EPC STORMWATER REVIEW COMMENTS
IN ORANGE BOXES WITH BLACK TEXT

GRADING AND EROSION CONTROL PLAN

JUDGE ORR ROAD RV PARK AND STORAGE

PCD PROJECT NO. PPR-16-040

JUDGE ORR ROAD RV PARK & STORAGE
COLORADO SPRINGS, COLORADO
DRAINAGE, GRADING & EROSION CONTROL DETAIL

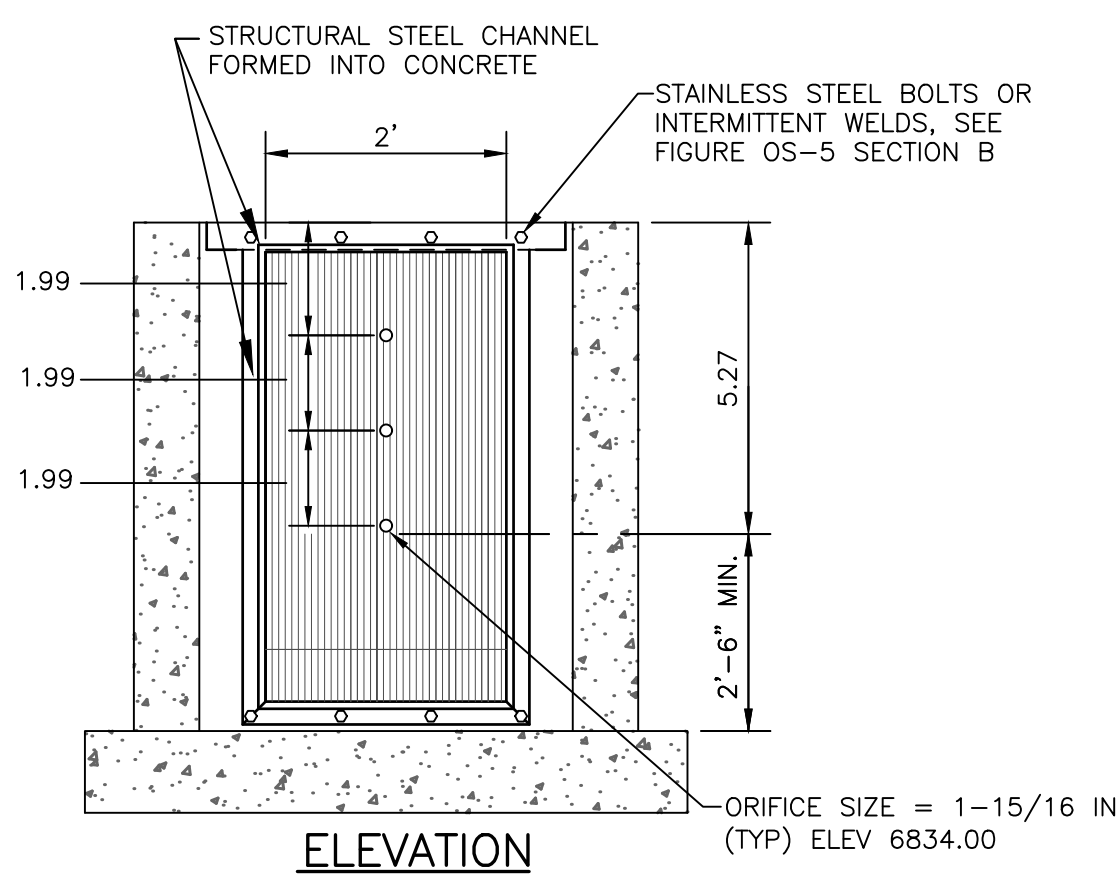
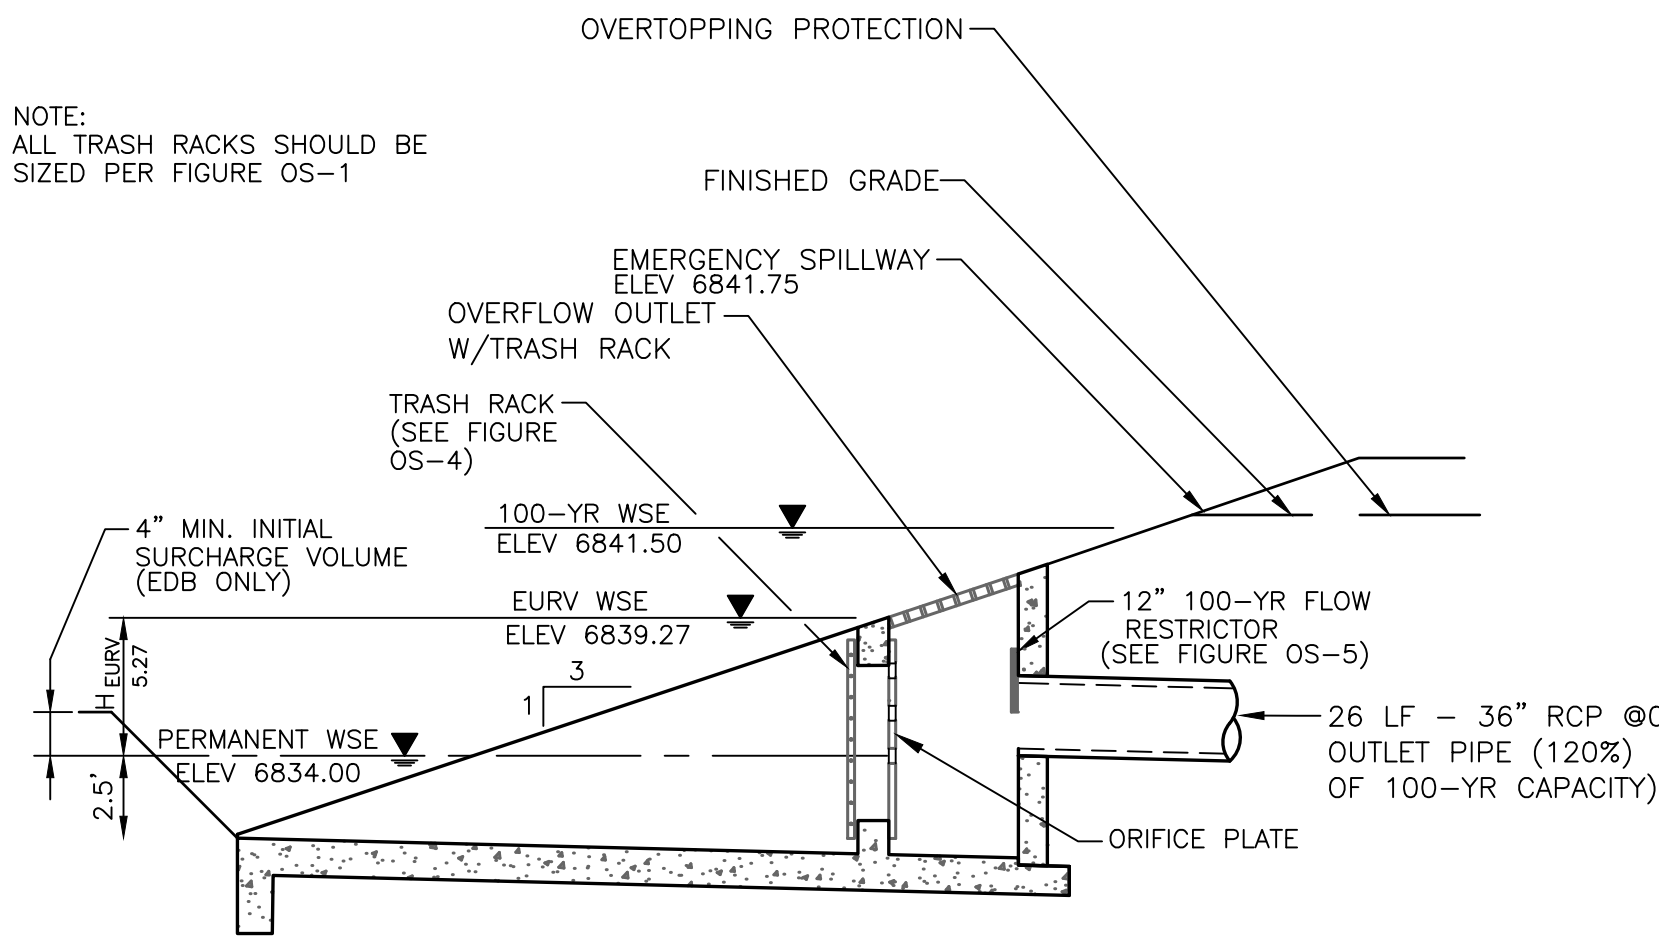
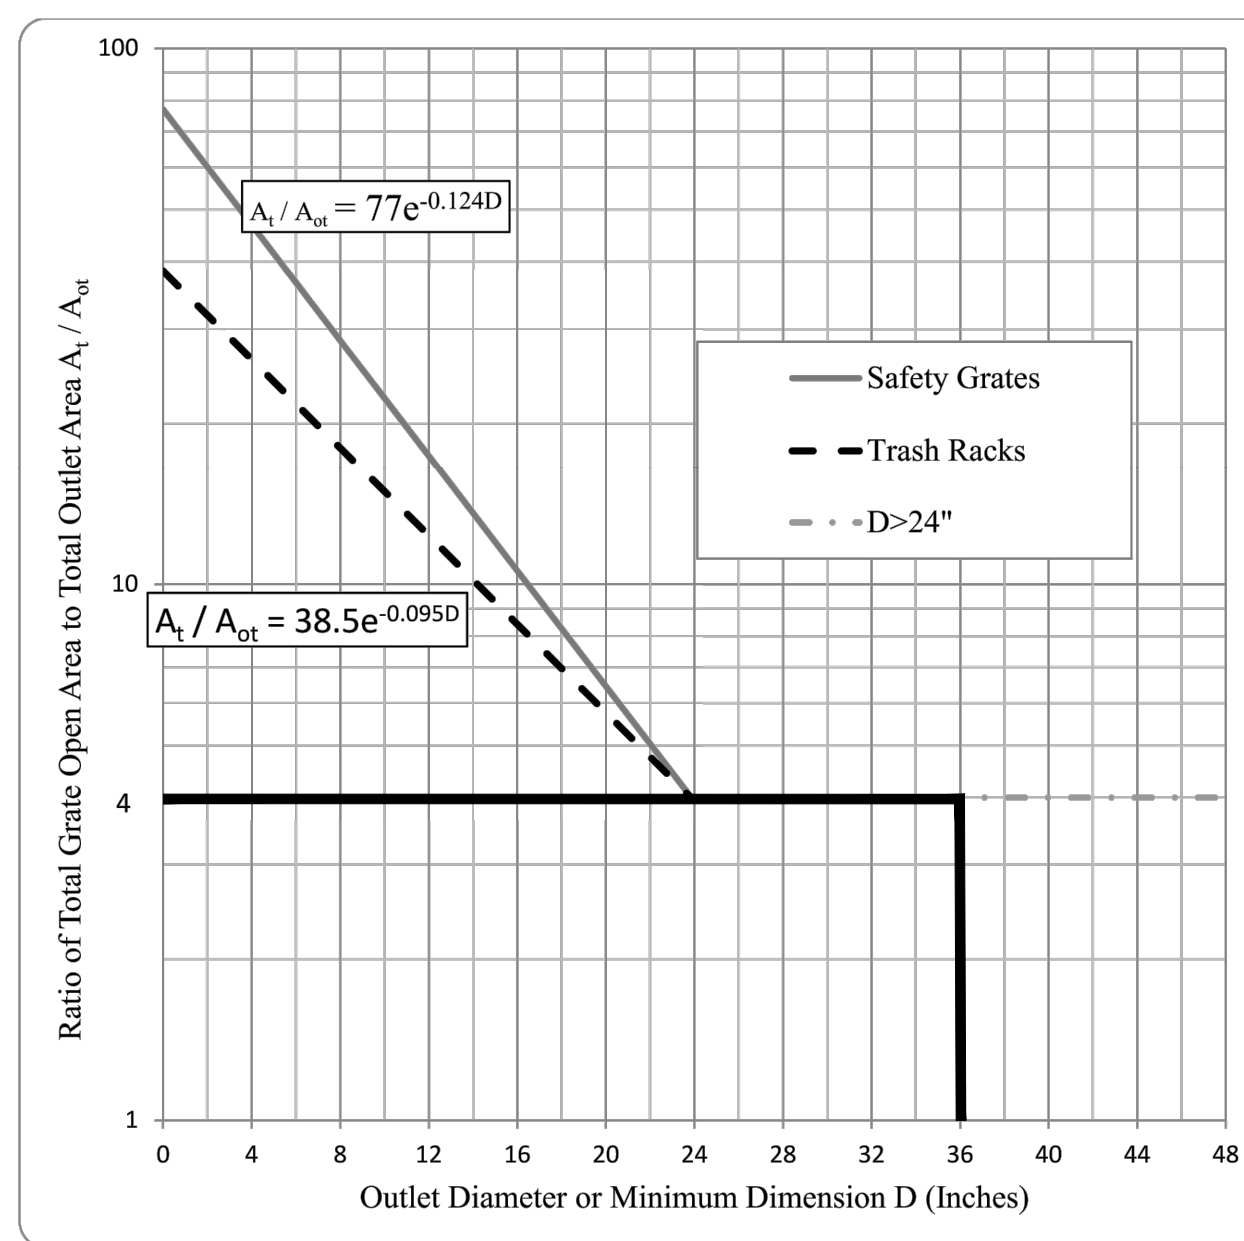
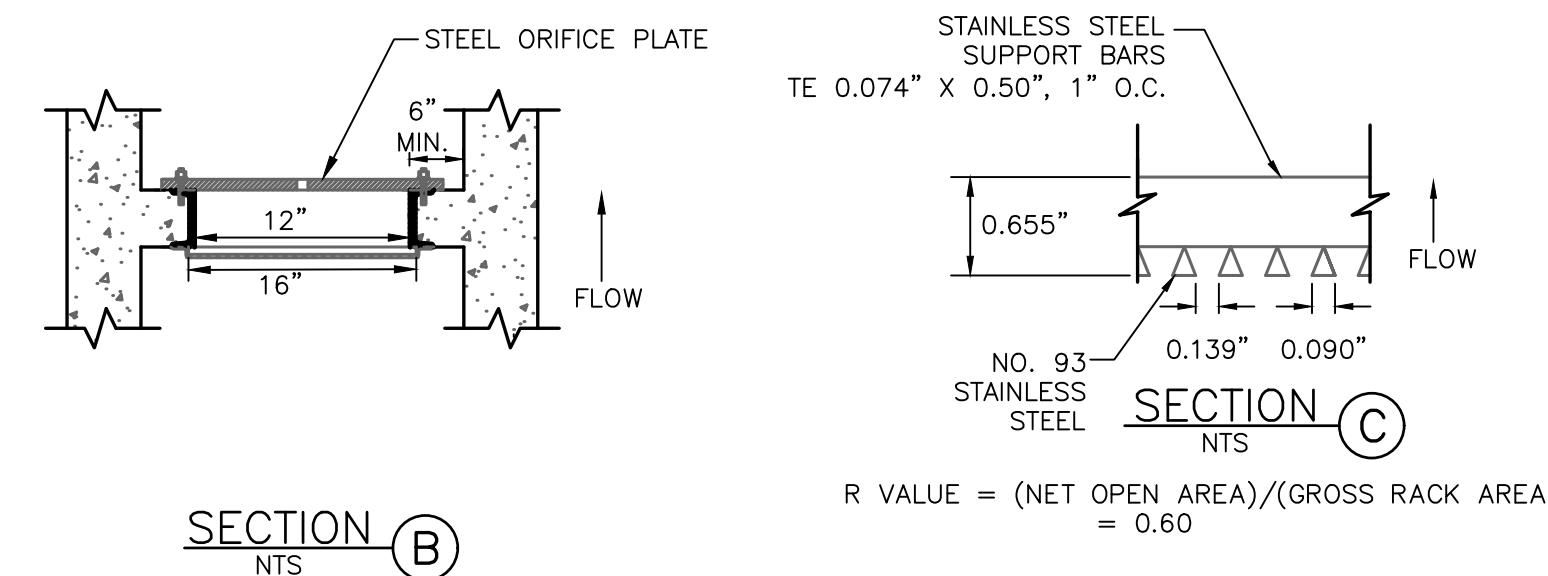
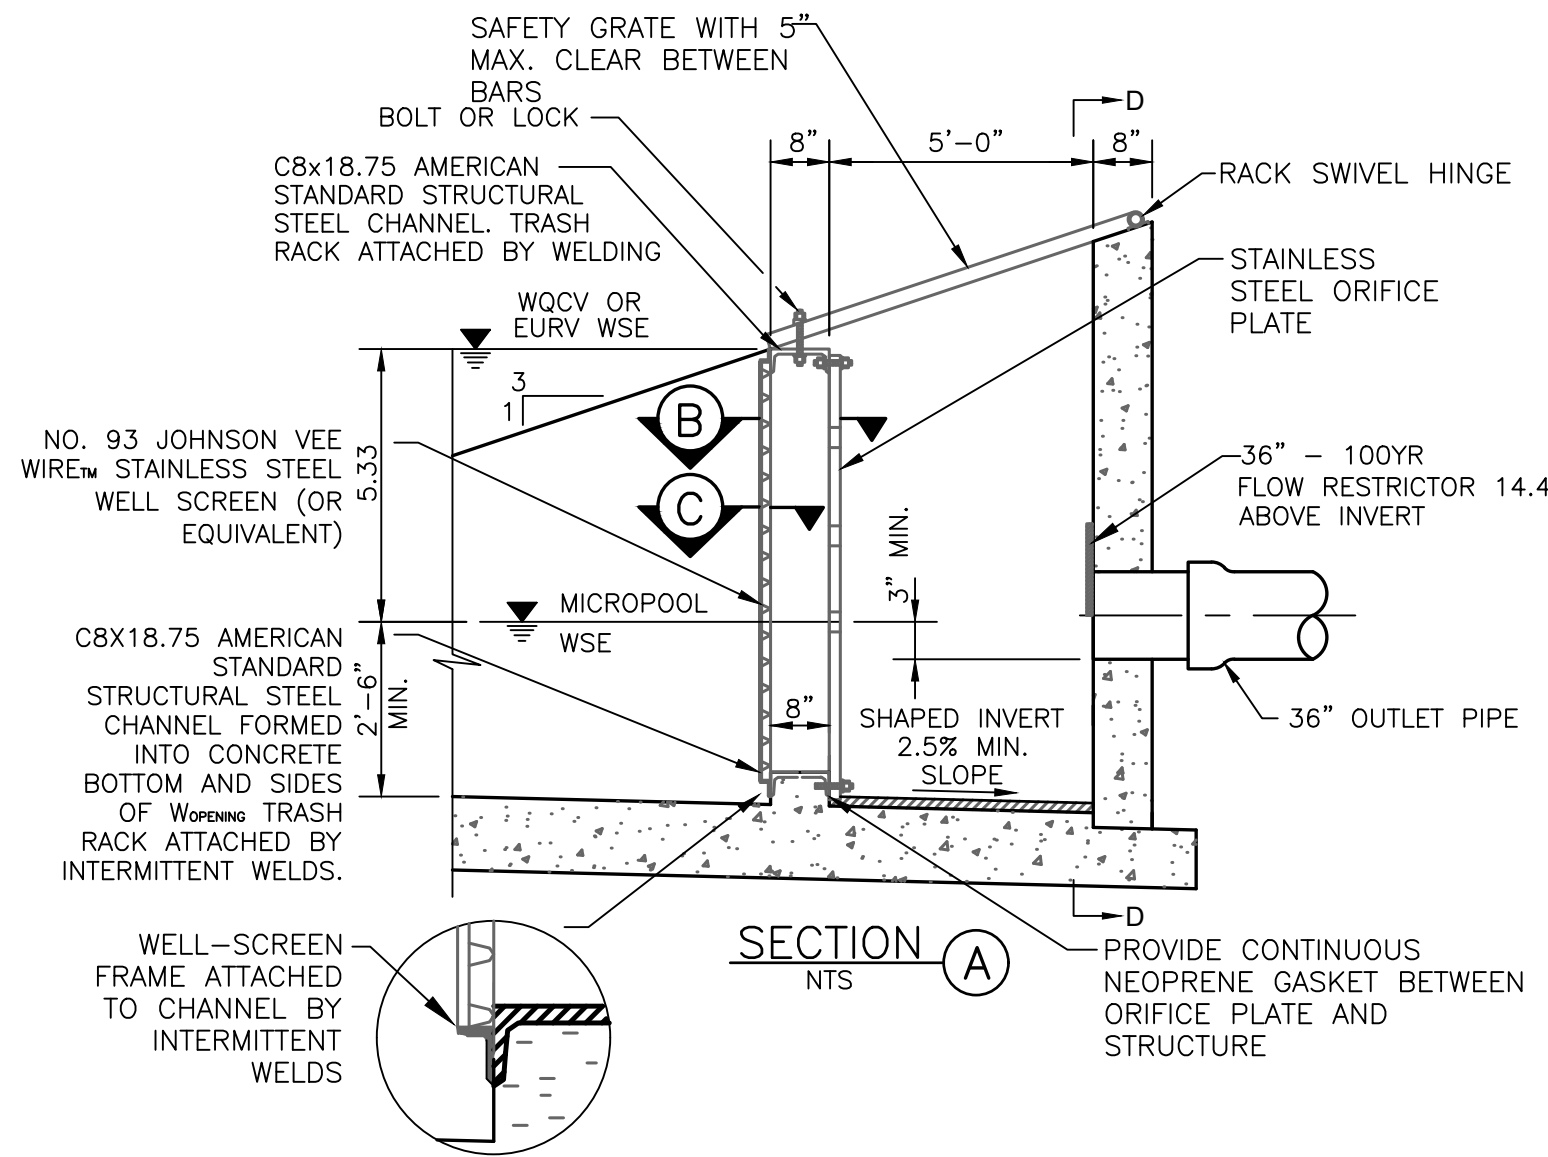
Please remove these pond details since no modifications are proposed to the pond. Acceptable just to label pond as existing.

Or add text across the top of this sheet "details for information only" or "pond built under PPR1640, no improvements required with CDR222"
